## **OXFORDSHIRE COUNTY COUNCIL'S RESPONSE TO CONSULTATION ON THE FOLLOWING DEVELOPMENT PROPOSAL**

**Application no:** 21/04202/F

**Proposal:** Redevelopment for 80 retirement living apartments including communal facilities, access, car parking and landscaping.

**Location:** Former Buzz Bingo, Bolton Road, Banbury

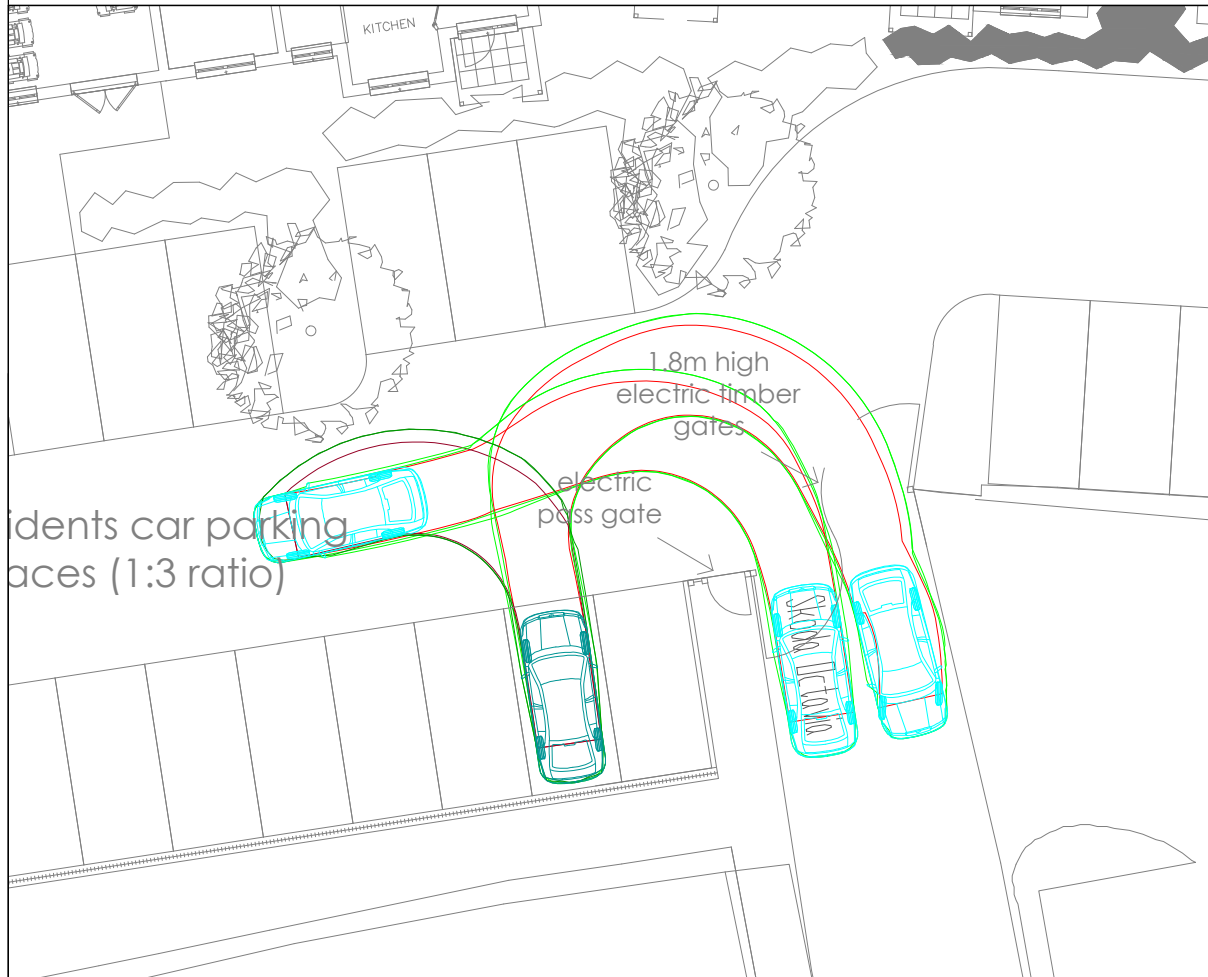
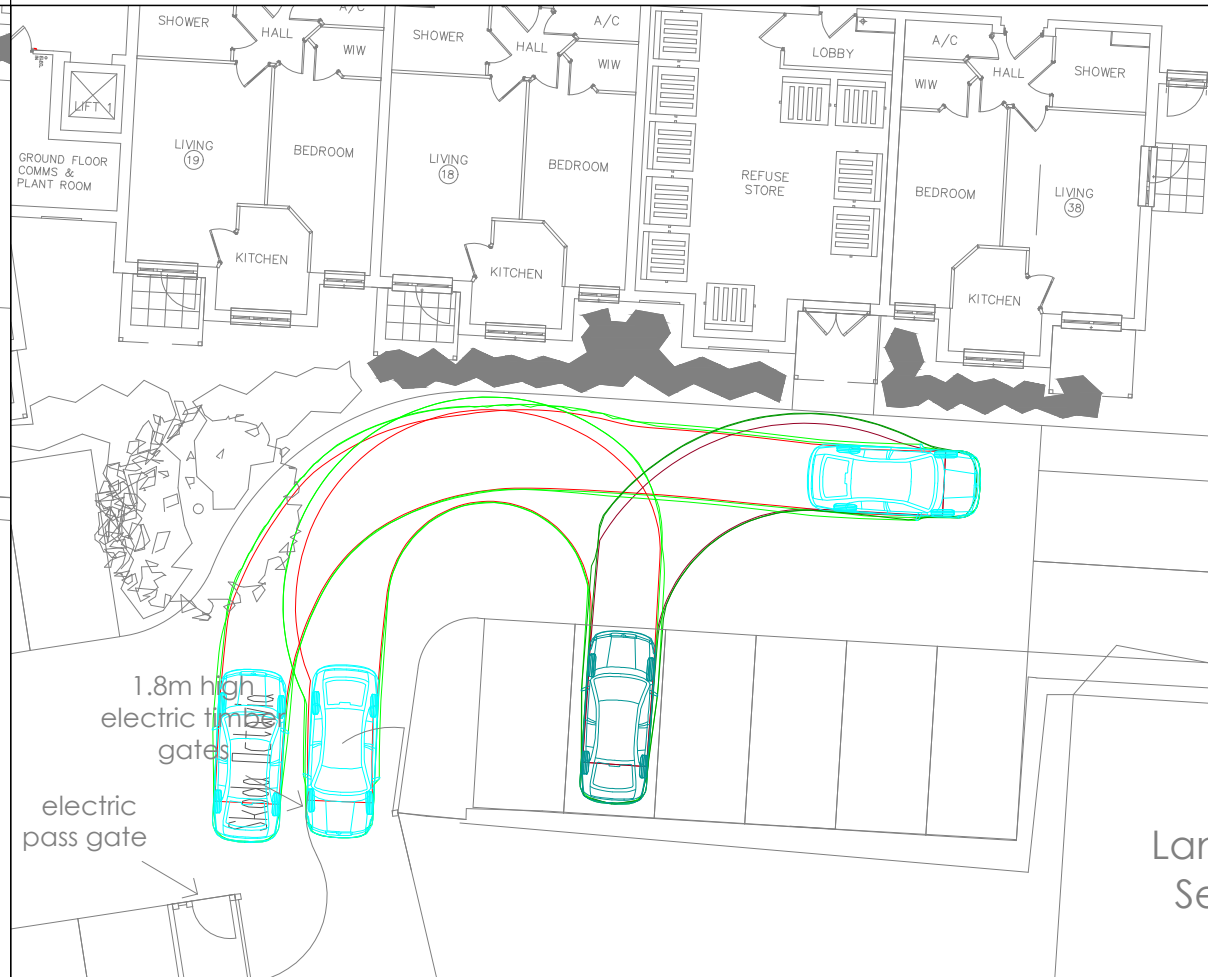
**Car Parking** - In the absence OCC's and Cherwell Design Parking Standards for retirement homes, 27 parking space arrangement is proposed for the development (at a ratio of 0.33 per unit). Vehicle tracking drawings has also been provided demonstrating access and egress manoeuvres, associated with the site and the proposed parking arrangement. Independent research of the existing Churchill Retirement homes confirms average car parking demand of 0.28 spaces per apartment which amounts to 22 parking space provision for the proposed 80 apartments. Based on proposed parking space provision, the Applicant asserts that overspill parking should not occur, however in the unlikely event that it arises, the nearby 58 space Bolton Road Car Park is available to accommodate. This statement is however made without providing any detail substantive support on the availability of parking spaces to accommodate this demand.

That said, no provision has been made for designated Staff, residents, visitor, and disabled parking bays nor EVCP bays in compliance with OCCs Standards within the

parking facility. OCC will expect the provision of 7 EVCP bays, with one EVCP allocated to a disabled parking bay. Also a parking/standing area for Taxi and Emergency Service Vehicle (e.g. Ambulance) is not evident in the Car Park layout proposal. A scaled and dimensioned parking layout plan capable of accommodating the manoeuvres and swept paths of different types of vehicles including a Fire Tender and Pentechicon will be welcomed
